CITY OF ALBUQUERQUE  
PLANNING DEPARTMENT  
DEVELOPMENT REVIEW BOARD

**6. Project # 1002375**  
06DRB-00902 Major-Vacation of Pub Right-of-Way  
06DRB-00903 Major-Vacation of Public Easements

DEVELOPMENT REVIEW BOARD – SPEED MEMO

**DRB CASE NO/PROJECT NO: 1002375**

VACATION ~~PLAT~~
**16' PUBLIC ALLEY AND THE
 REMAINING PORTION OF LOMA HERMOSA PLACE
 THE PALISADES**

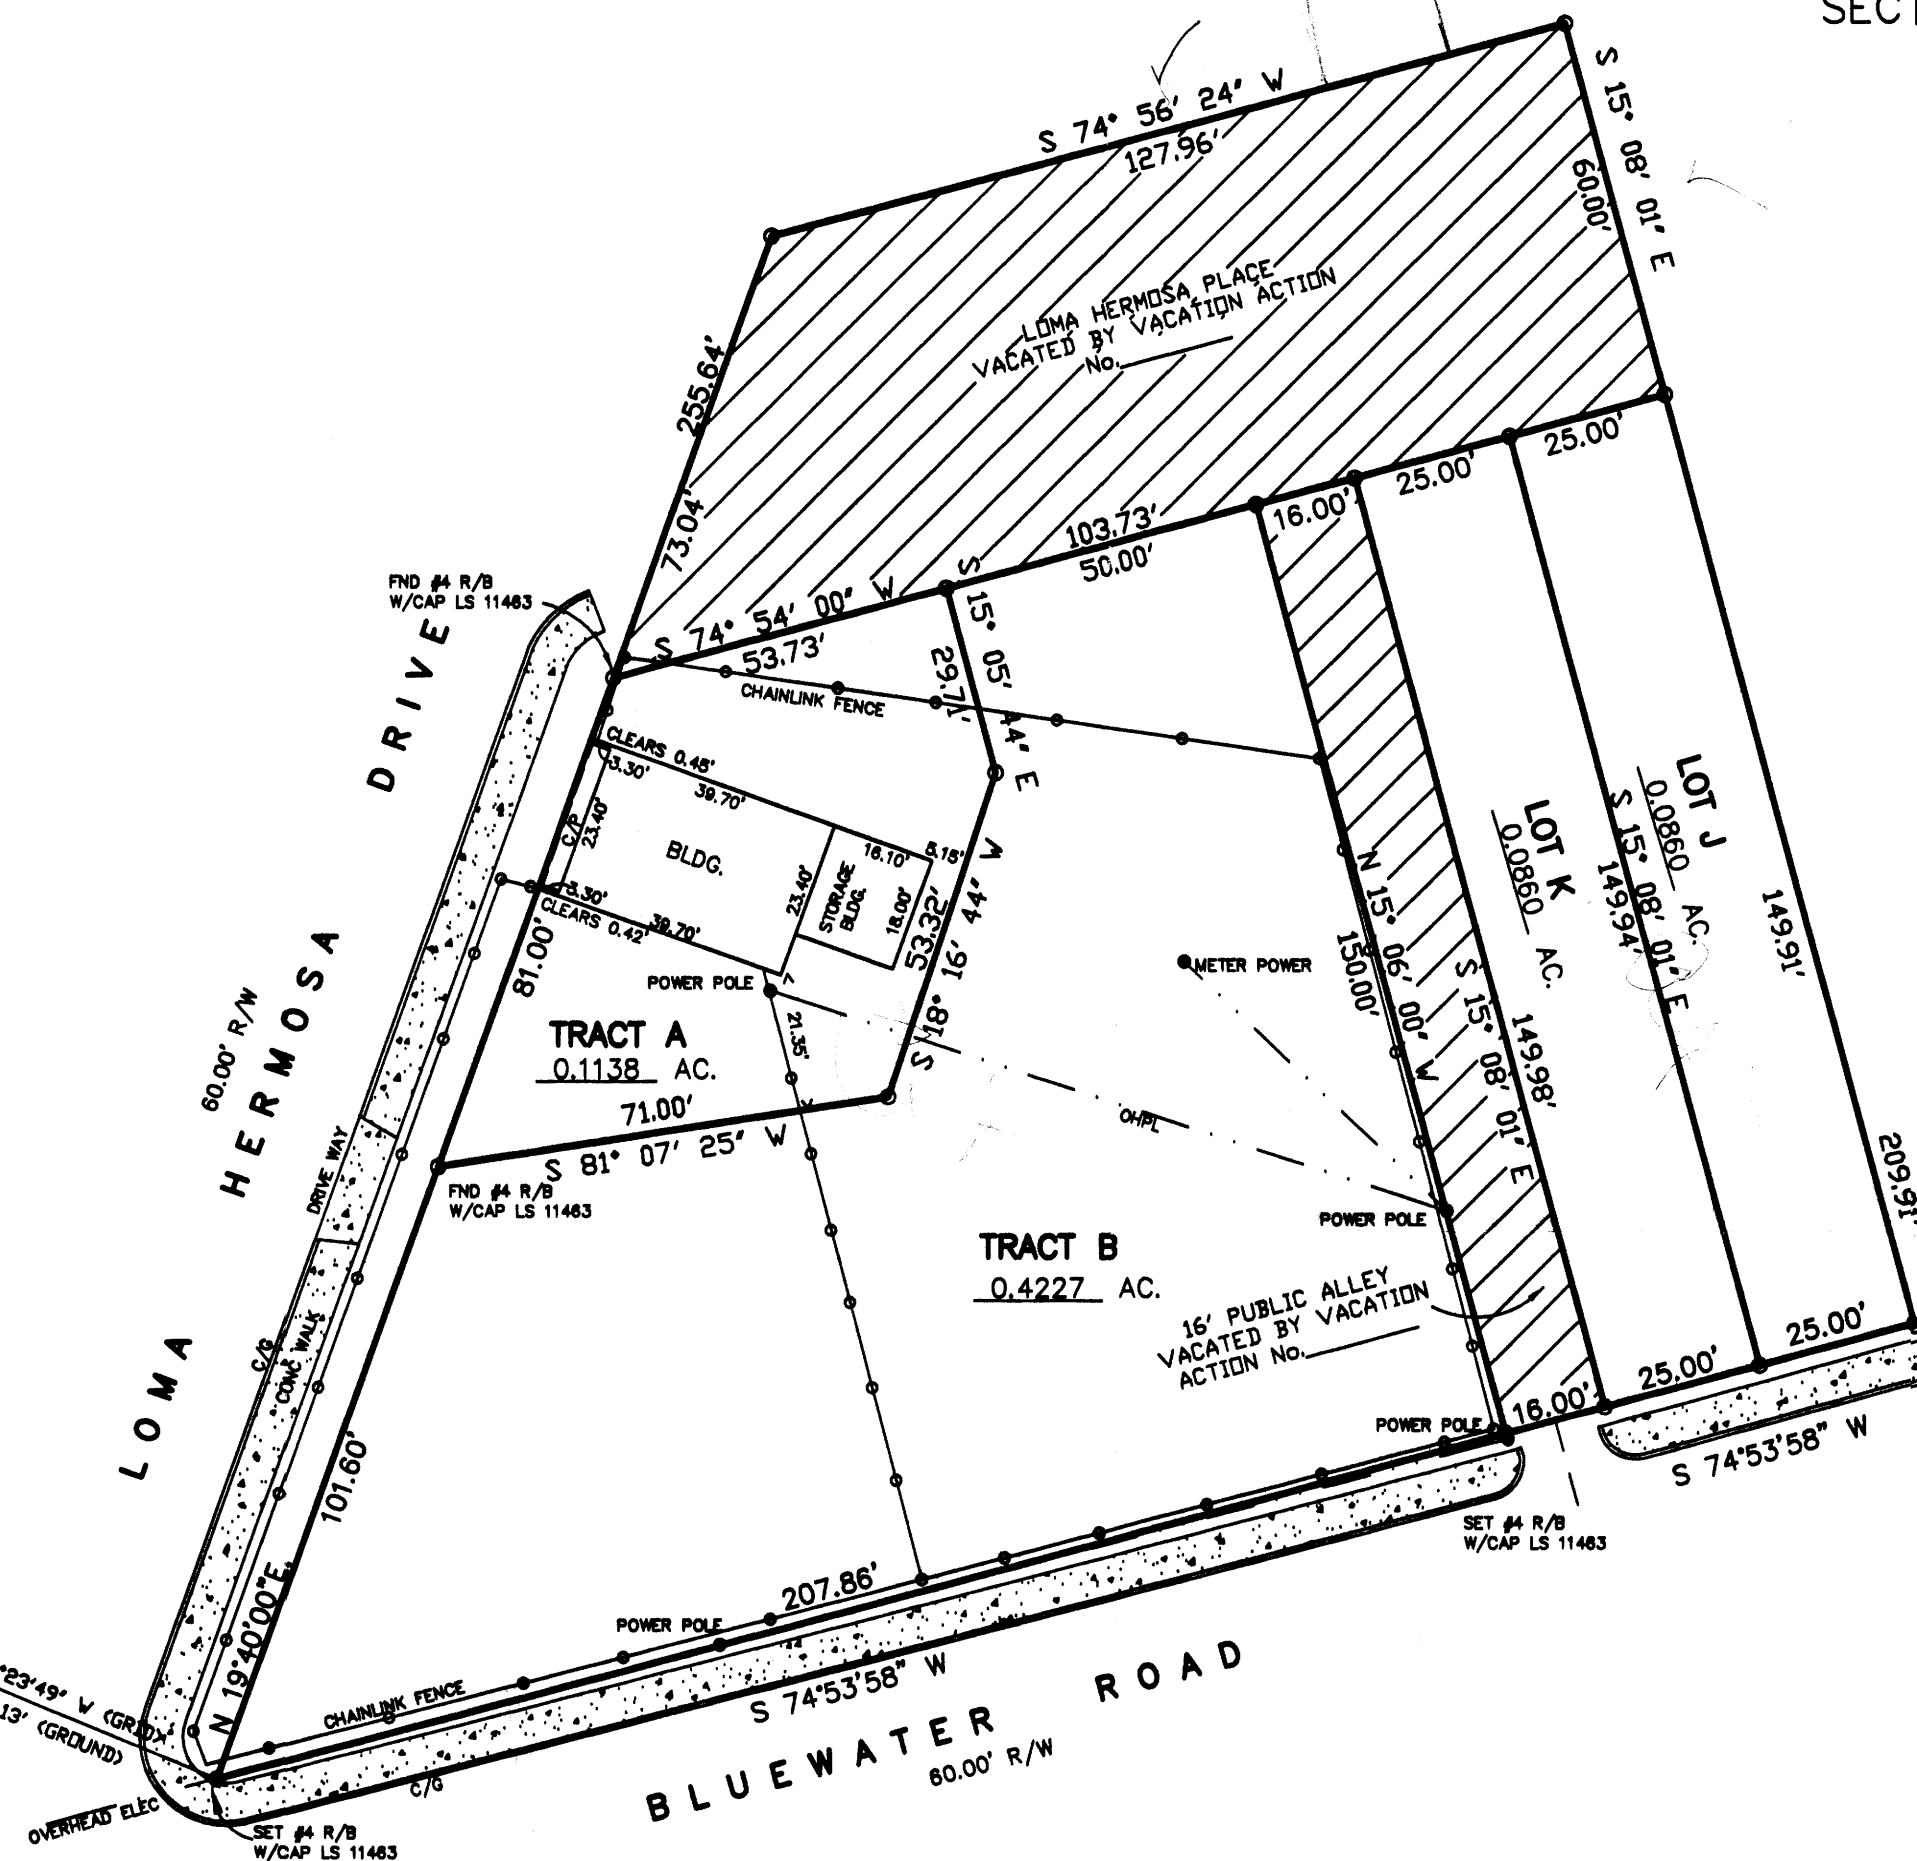
The design engineer must provide proof that the right-of-way is not needed to convey public drainage.
